Our Case Number: ABP-317660-23

**Re:** Busconnects Kimmage to city centre core bus corridor scheme  
Kimmage, Dublin

## KIMMAGE TO CITY CENTRE CORE BUS CORRIDOR SCHEMELANDSCAPING AND URBAN REALM

Programme Title BUSCONNECTS DUBLIN CORE BUS CORRIDORS INFRASTRUCTURE WORKS				
Drawing Title KIMMAGE TO CITY CENTRE CORE BUS CORRIDOR SCHEME LANDSCAPING AND URBAN REALM				
Drawing File Name BCIDD-ROT-ENV_LA-0011_ML_00-DR-LL-0001	Sheet Number 01 of 14	Status A	Rev M01

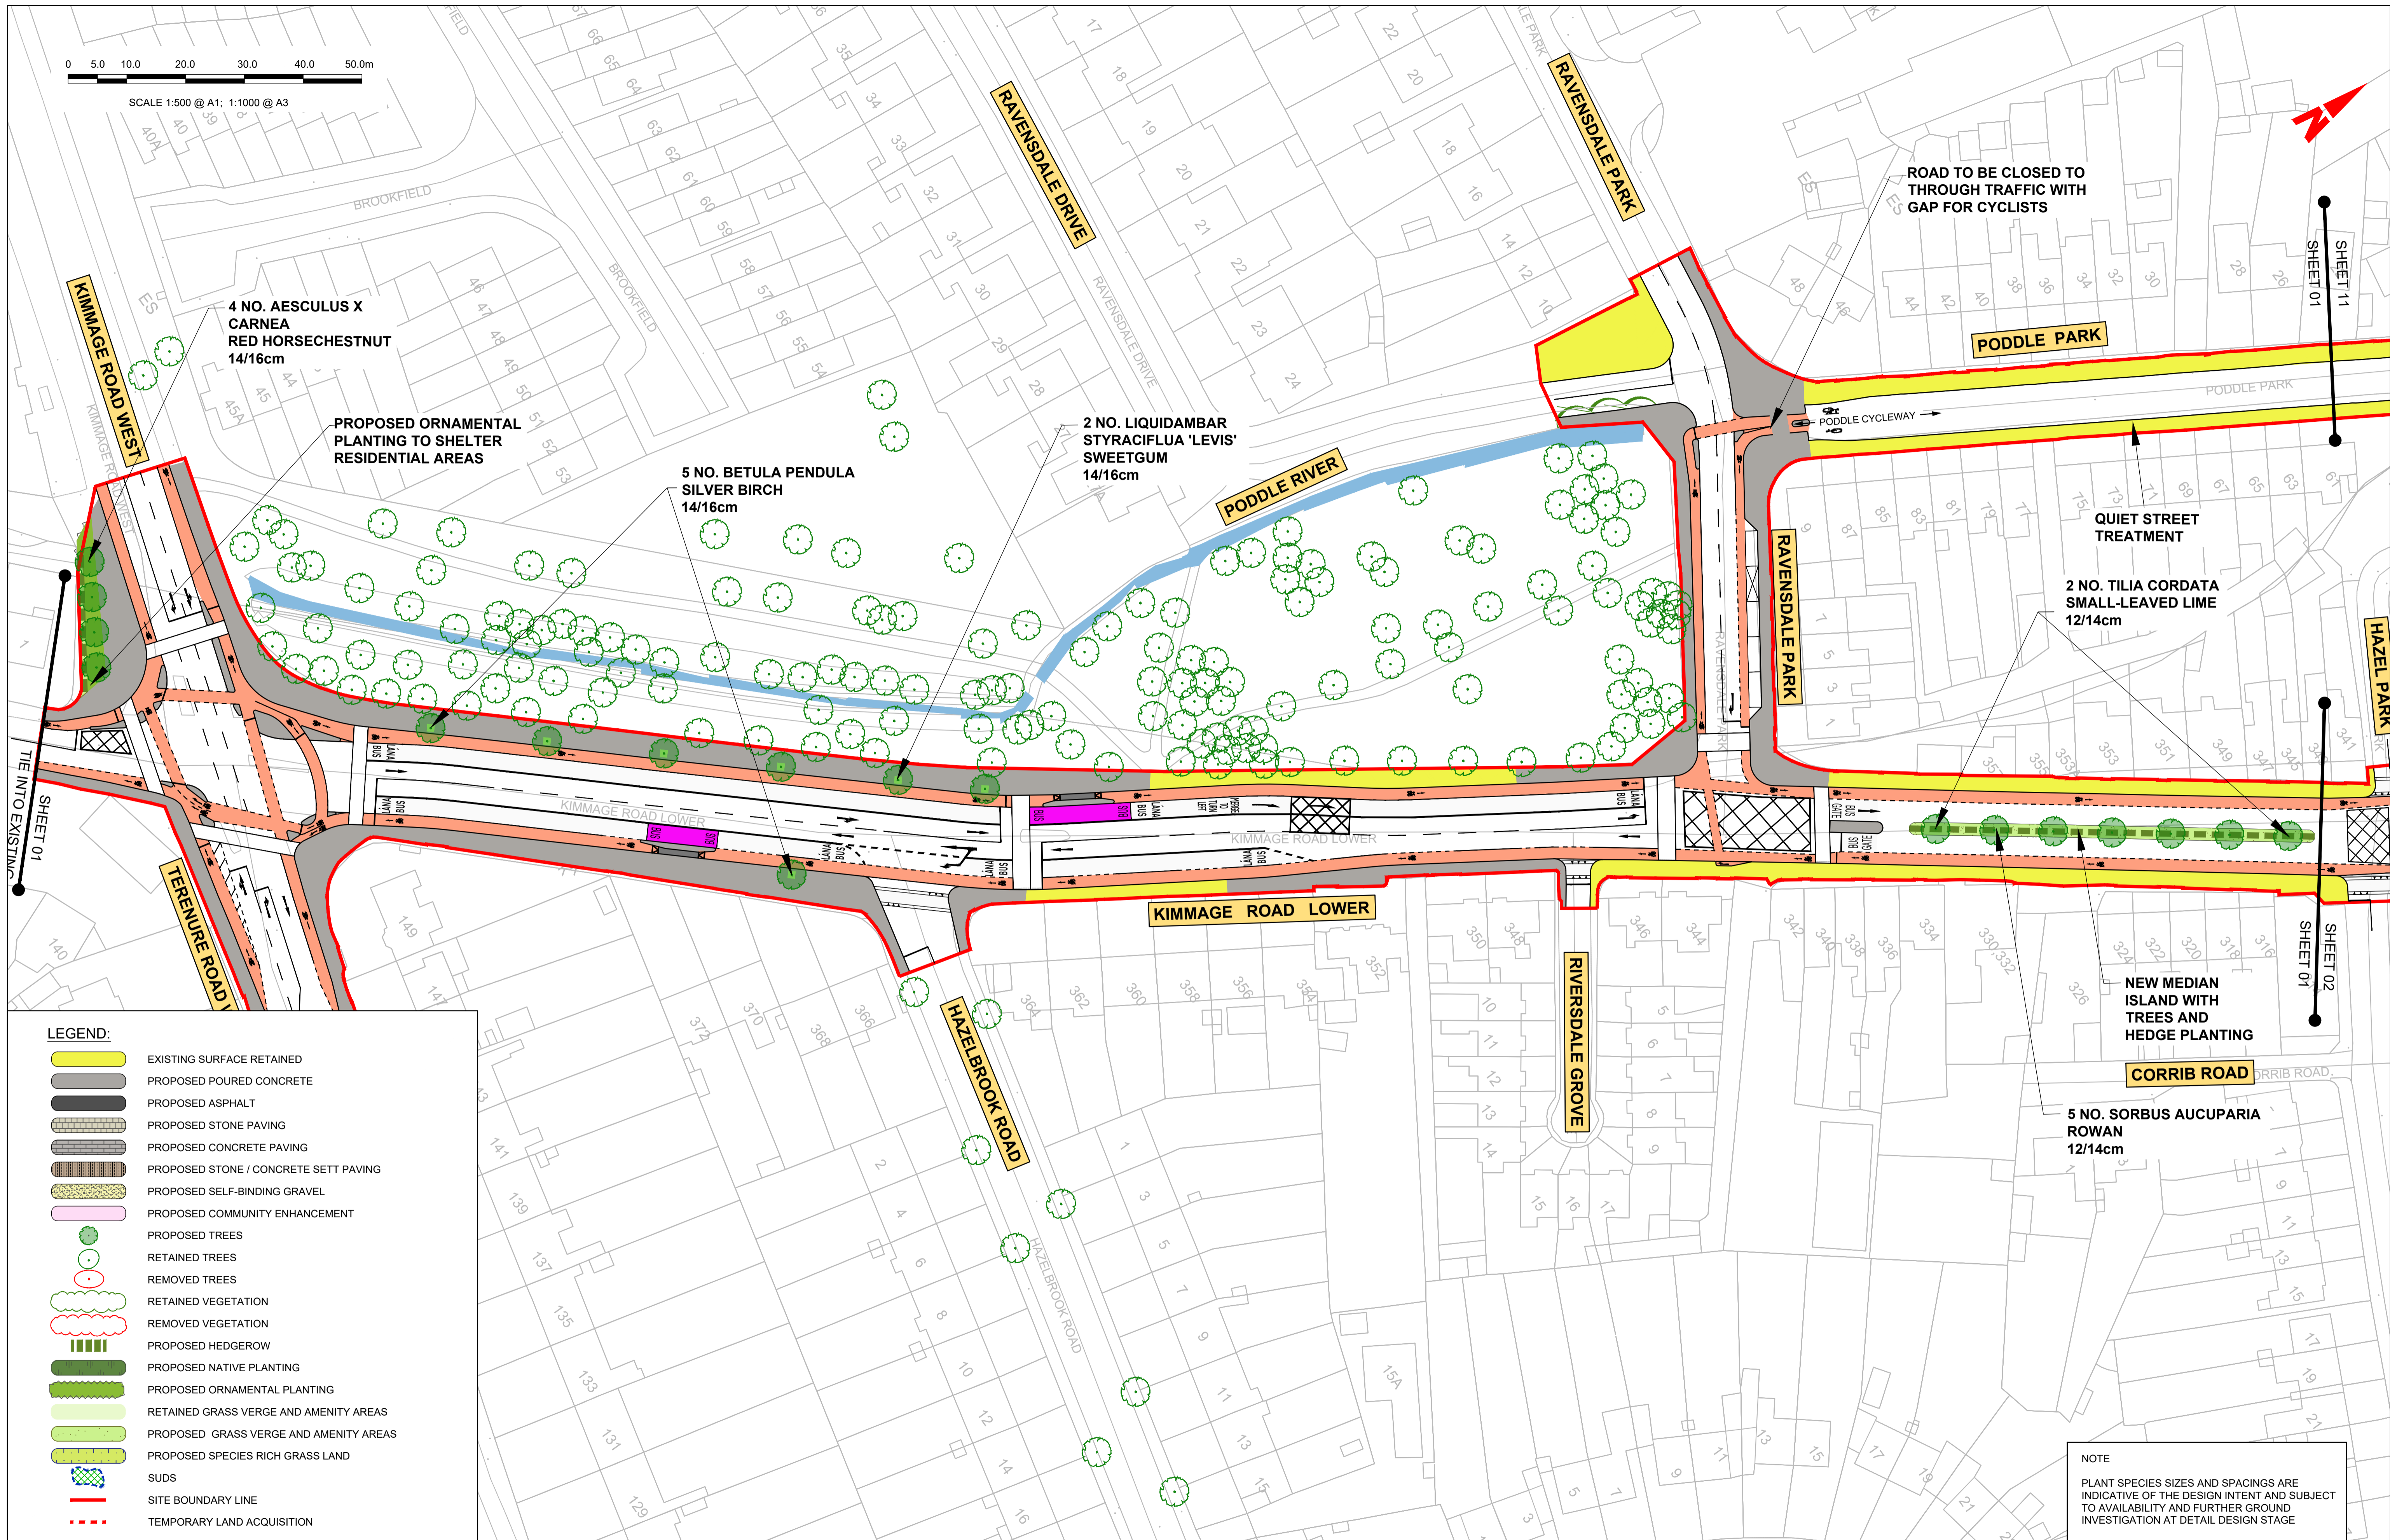
More ambitious provisions of new trees should be provided while works are underway to promote sustainability. Existing trees outside boundary line of works have been included which suggest more trees are being installed than it appears until legend is read. Works outside red line is not relevant and they should be not be included on the application as it appears to overstates trees actually being provided.

There has been already lost opportunities to provide more tress on Sundrive Rd & Parnell Road footpaths / pedestrian crossing improvements where mass concrete has been provided where there was an opportunity to increase tree provisions within the city.

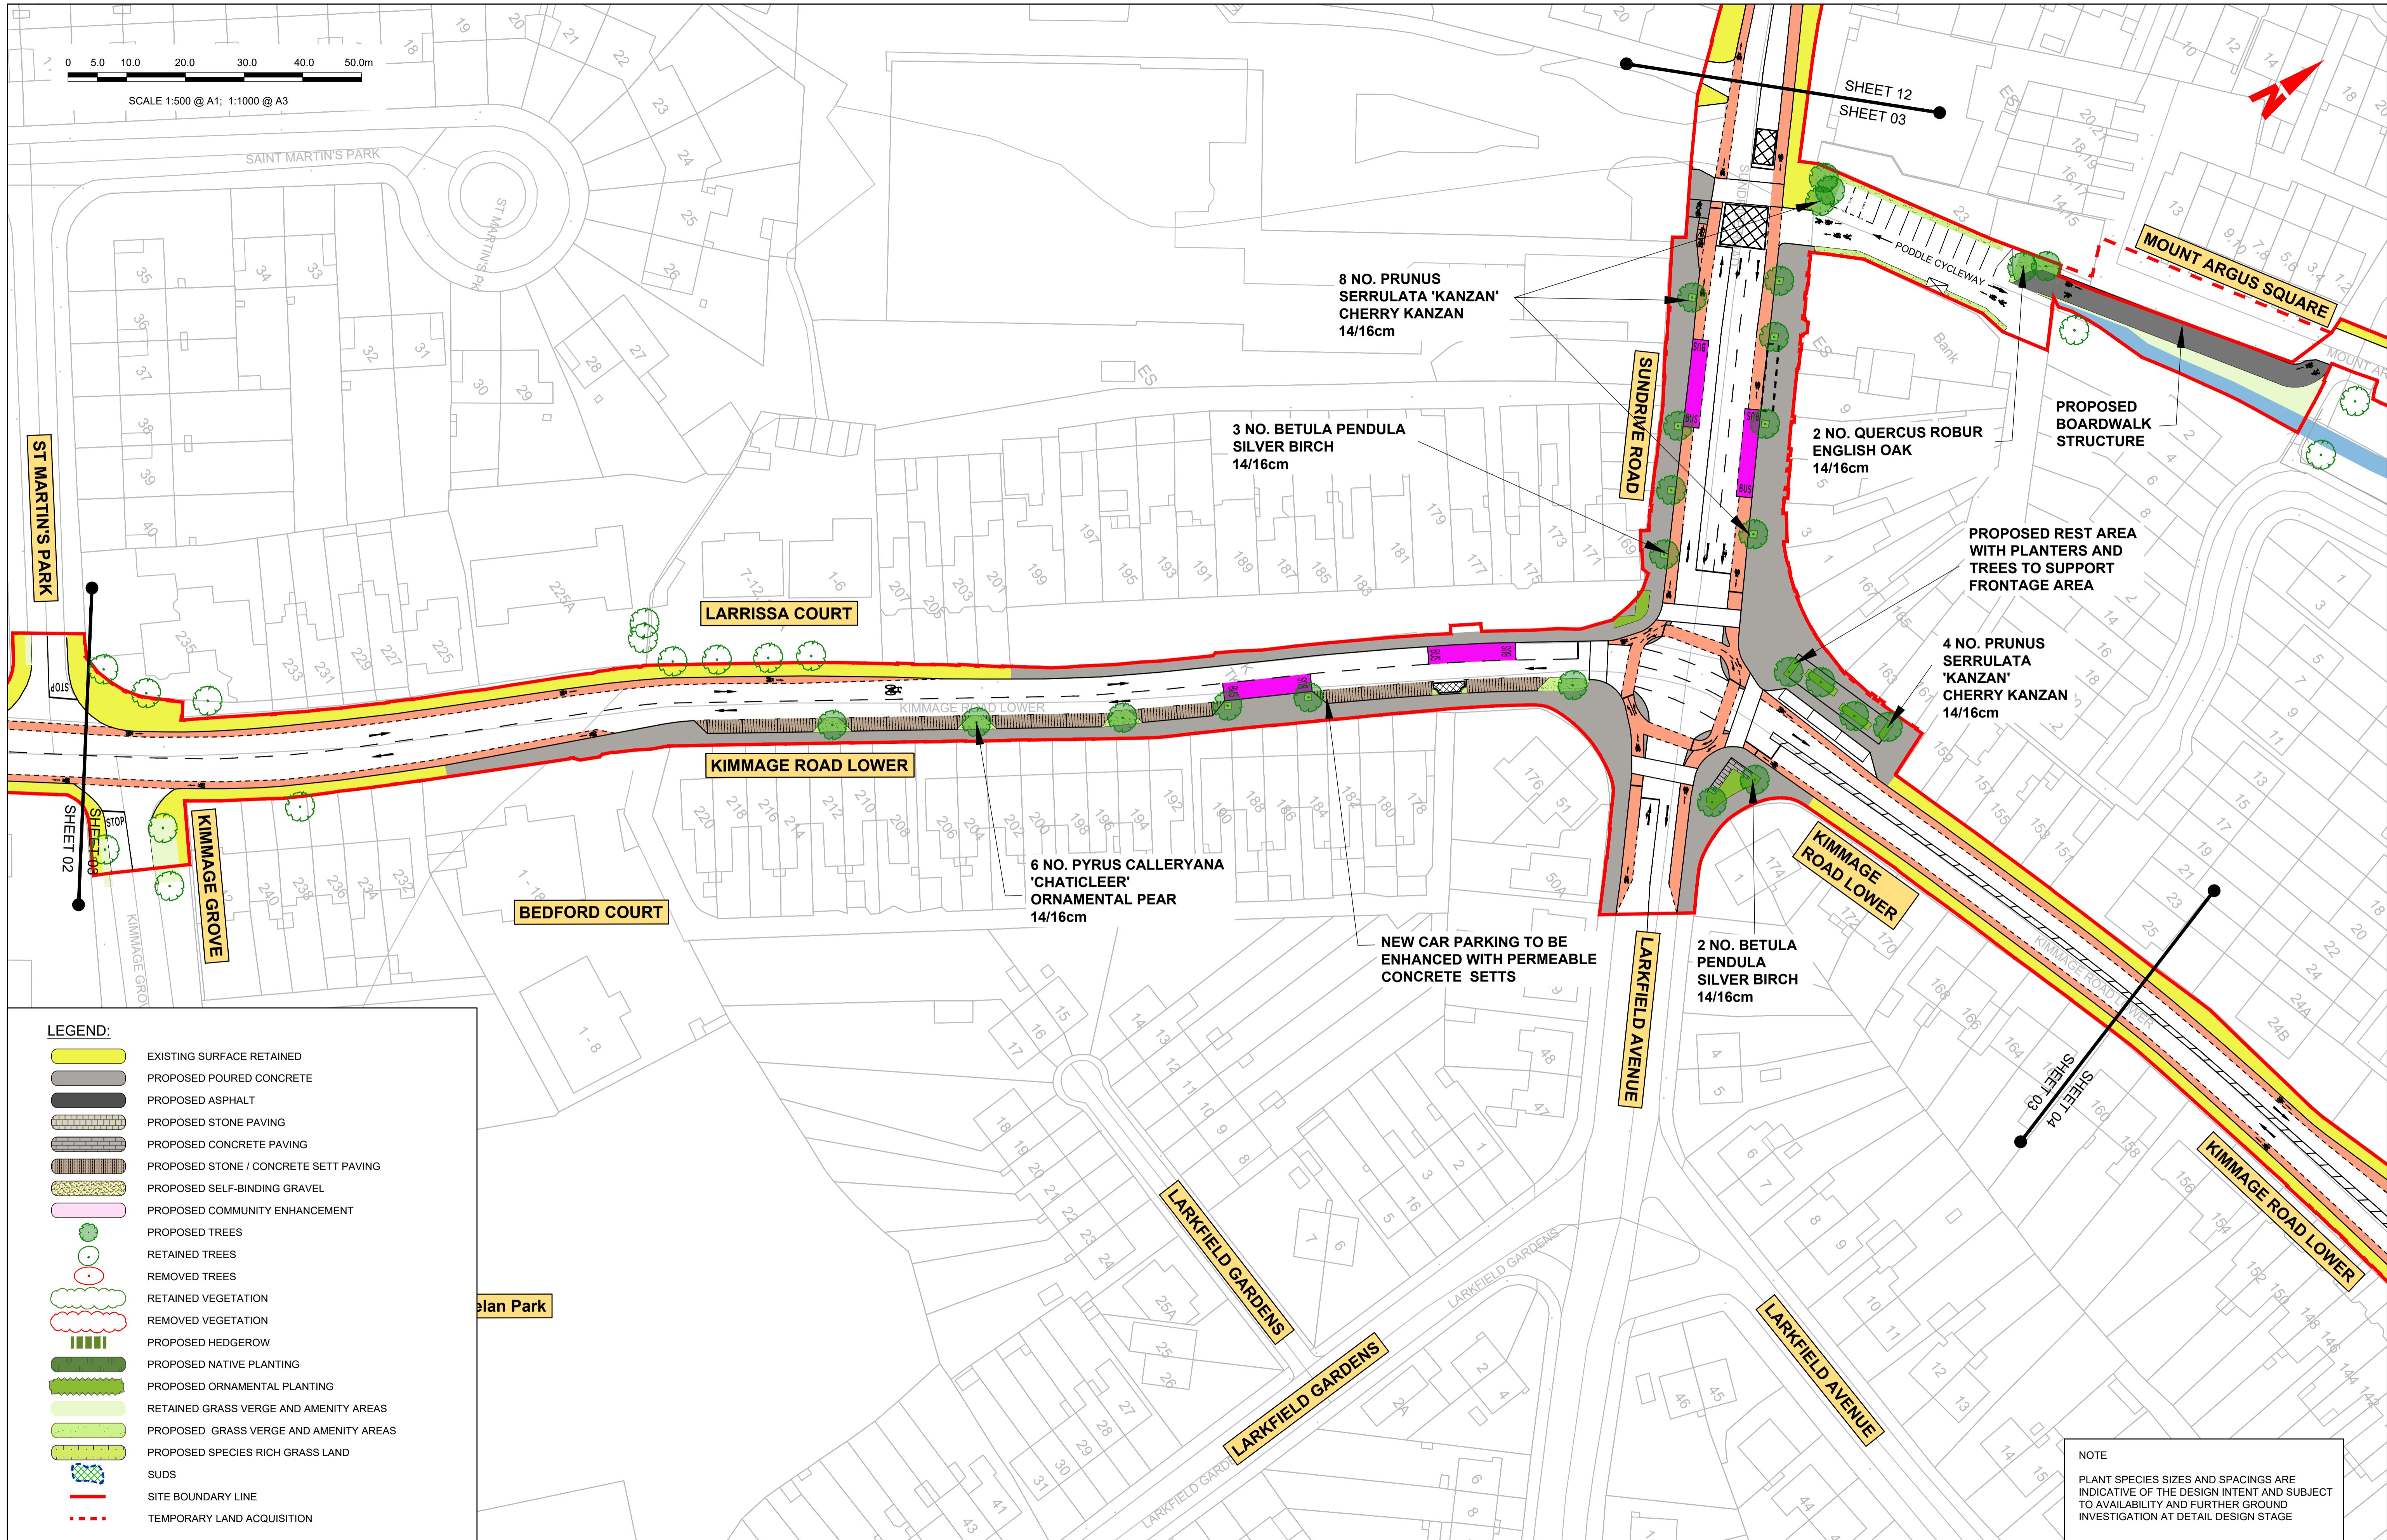
There are existing telephone / light / sign poles which are poorly located which prevent two way traffic due to minimum distance between poles & boundary wall to footpath. It is an particularly an issue when meeting with prams or wheelchairs The concrete foot paths have been shown as yellow indicating no amendment to locations. These poles should be repositioned while the improvement works are underway. Suggest survey carried out to determine locations to full layout (sheet 1 – 14) and correct amend within layouts. See below photo for example

There are less tree provisions being provided to Lower Kimmage Road / Sundrive Rd road junction than was shown in the preferred route PDF issued previously. Suggest increasing.

**BCIDD-ROT-ENV\_LA-0011\_ML\_00-DR-LL-0003 Sheet 3 of 14**

There is an opportunity to provide high quality amenity space to Sundrive Road / Lower Kimmage junction and surround. Granite / stone paving should be used to promote foot traffic / community sustainability and more ambitious public landscaping / street furniture should be provided.
